Our Ref: EP/133/19/DOC

Approval of details reserved by condition imposed under ref EP/160/16/PL relating to Condition Nos 6 - trees/bushes/hedges retention/protection, 7 - landscaping scheme and 8 - Construction Management Plan

Green Willow Residential Care Home Vicarage Lane East Preston BN16 2SP

Dwg. No. 21628 / 28

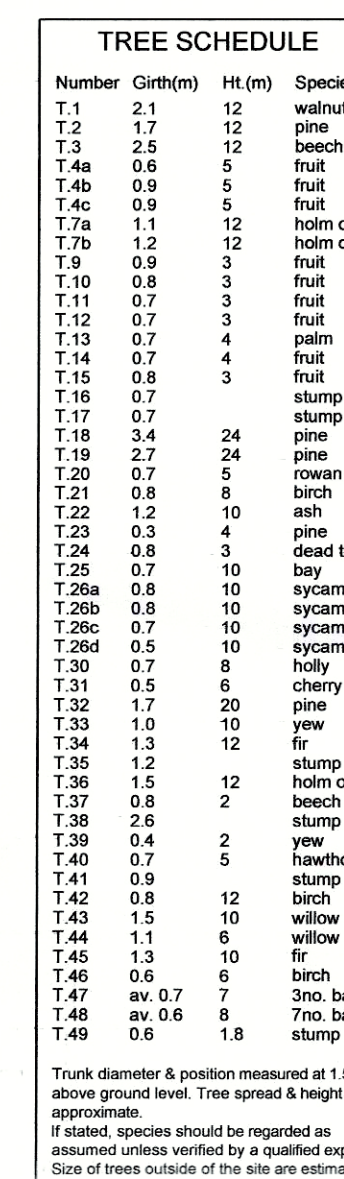
The proposed Landscape Plan (drawing no. 212628/28) fails to provide sufficient detail of species choice, actual quantities being proposed, planting densities and size at time of planting. In order for the discharge of this condition to be approved, this information needs to be shown in conjunction with an

accurate plan of existing vegetation to be retained, in order to ensure that appropriate screening has been considered and a full assessment can be made.
